Department of Planning, Industry and Environment  
4 Parramatta Square, 12 Darcy Street  
Parramatta NSW 2124  
Attention: Rodger Roppolo

<b>Your Reference</b>	SSD 880-7942
<b>Our Reference</b>	NCA/4/2017
<b>Contact</b>	Kate Lafferty
<b>Telephone</b>	9806 5393
<b>Email</b>	klafferty@cityofparramatta.nsw.gov.au

**COUNCIL COMMENTS – MODIFICATION OF APPROVAL (SSD-7942-Mod-1)  
OPEN WATER SURF FACILITY - POD B P5 CARPARK – HILL ROAD, SYDNEY OLYMPIC PARK**

Please be advised that Council officers have reviewed the documentation submitted for the proposed modifications to the approved URBNSURF open water surf facility. The following comments are provided as a result of the review of the exhibited documents.

DRAWING
TREE RETENTION AND REMOVAL PLAN

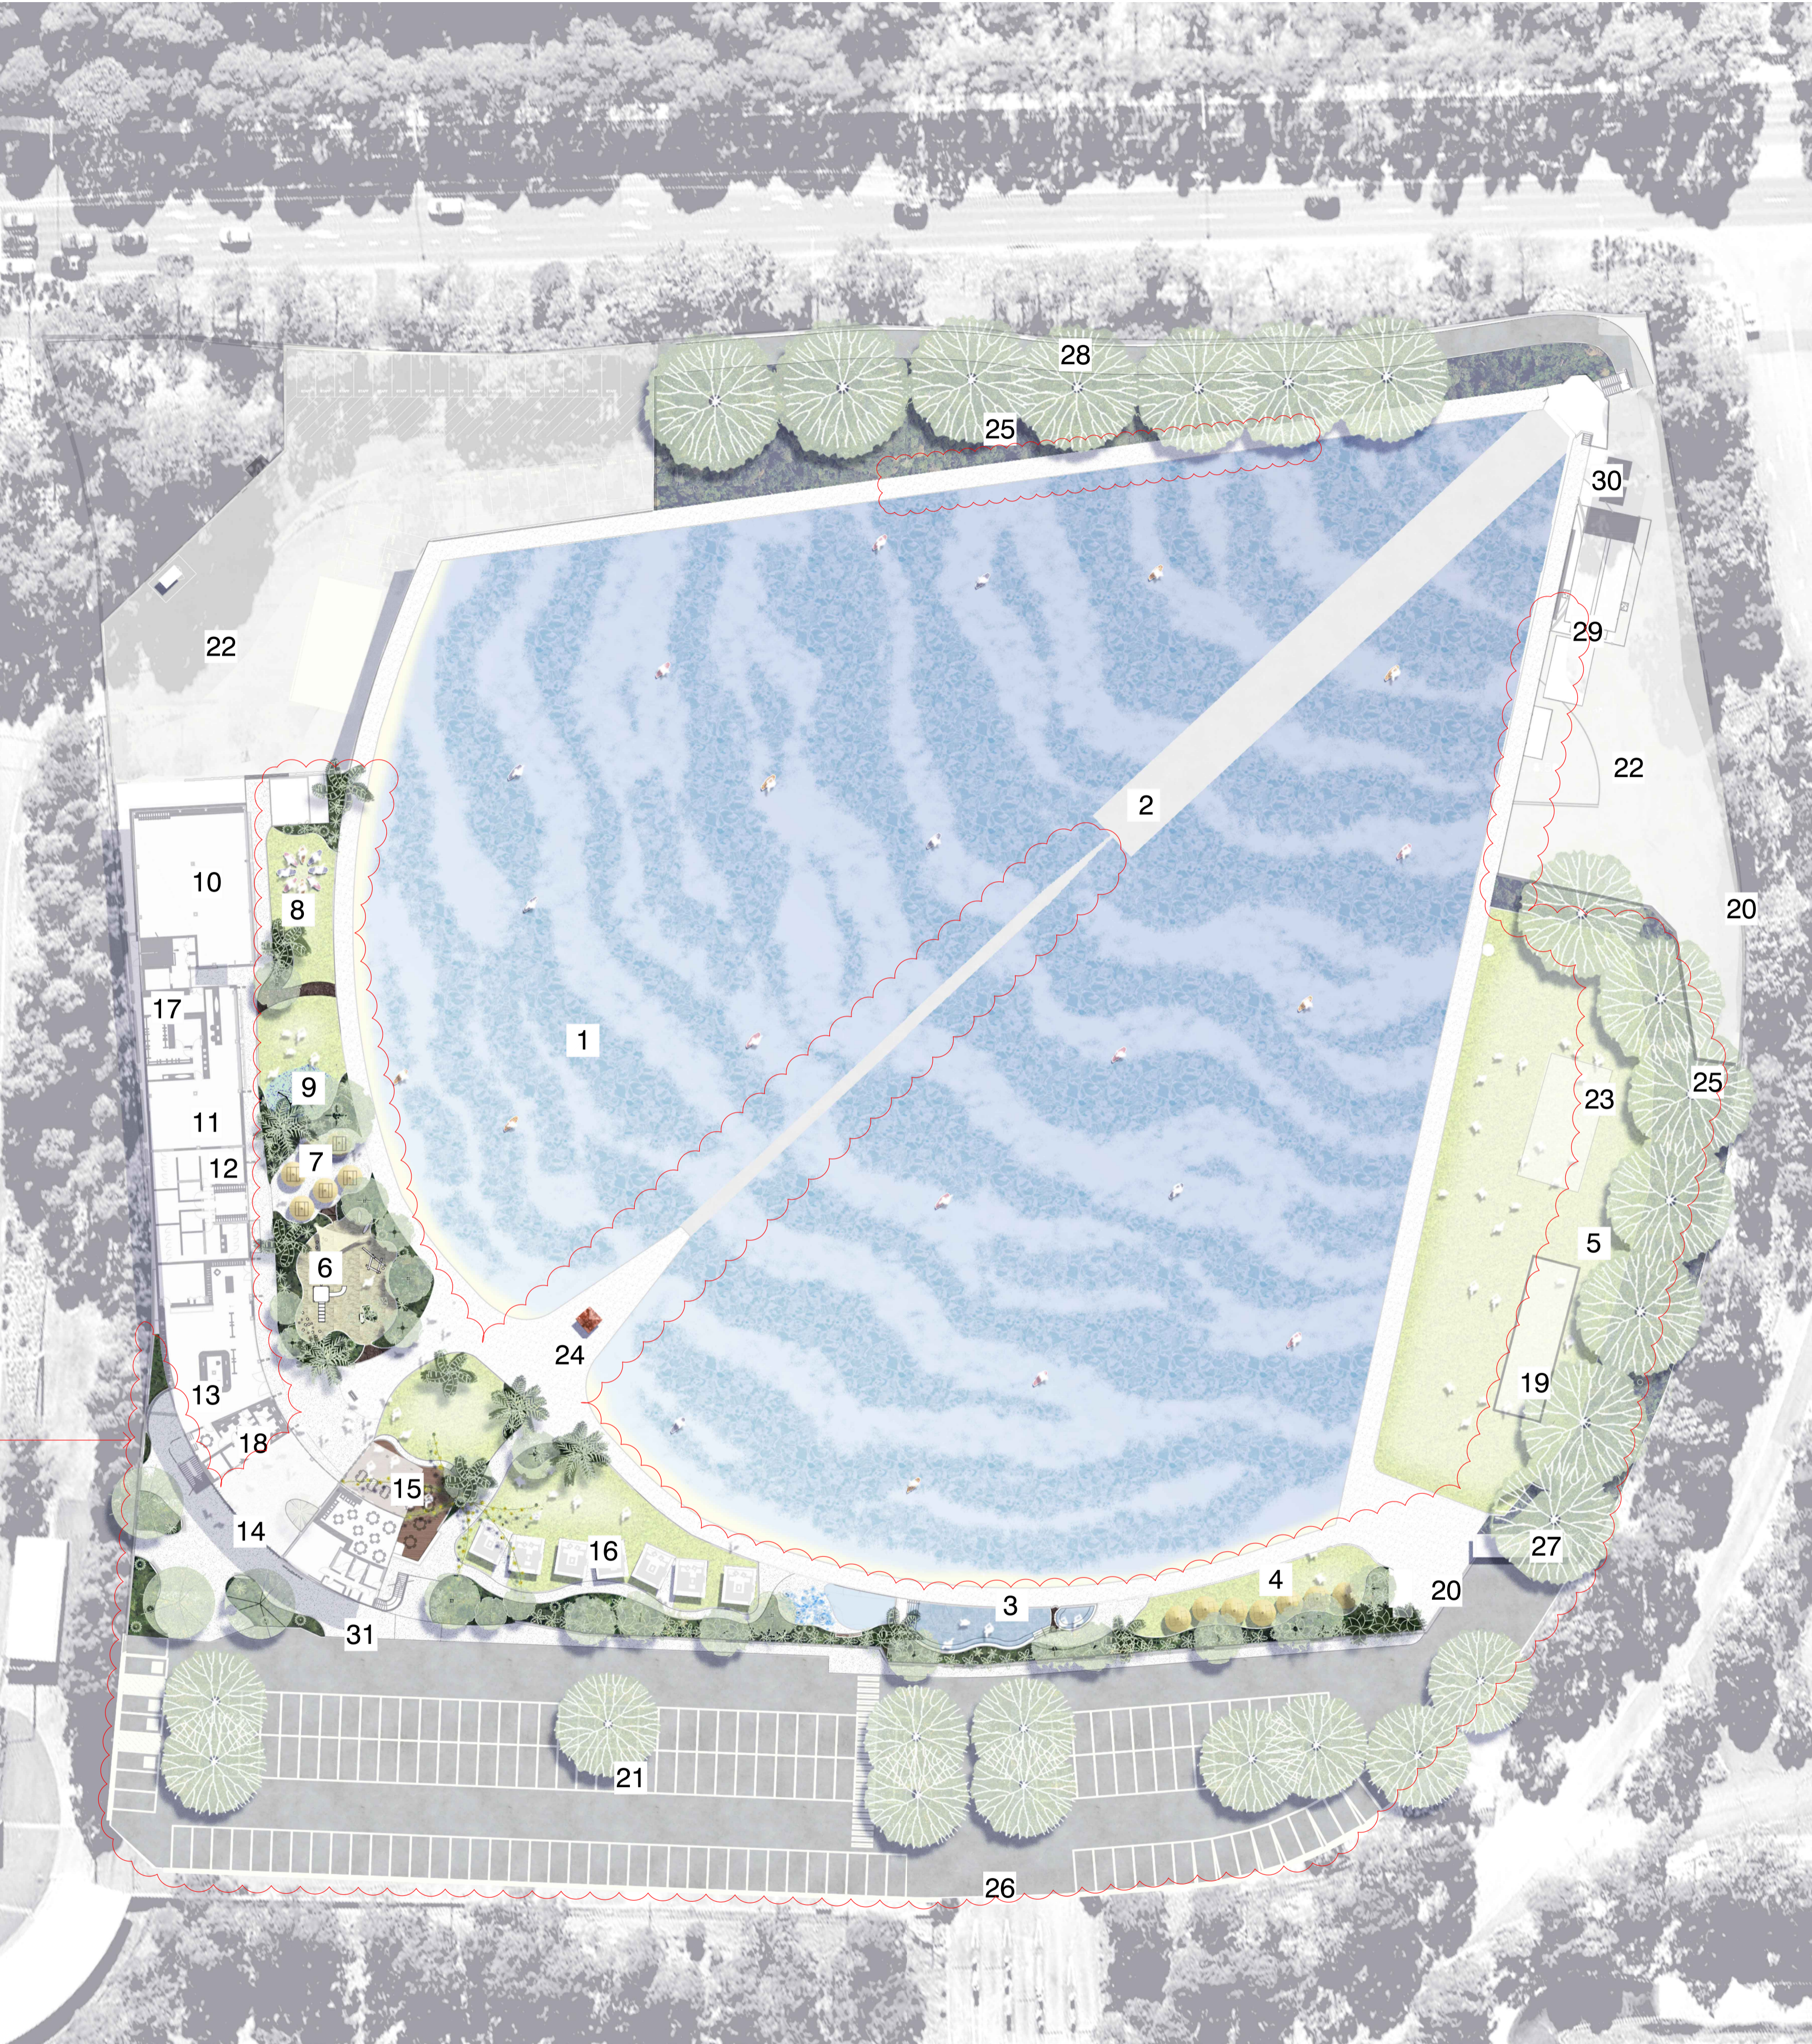
It is acknowledged that additional tree removal is proposed from the existing carpark area. No specific concerns are raised regarding removal of these additional trees, however it is strongly recommended that further consideration be given to the provision of substantial shade tree planting in order to reduce the heat island effects within the hardstand areas. In this regard, it is recommended that additional trees be planted within the car parking area.
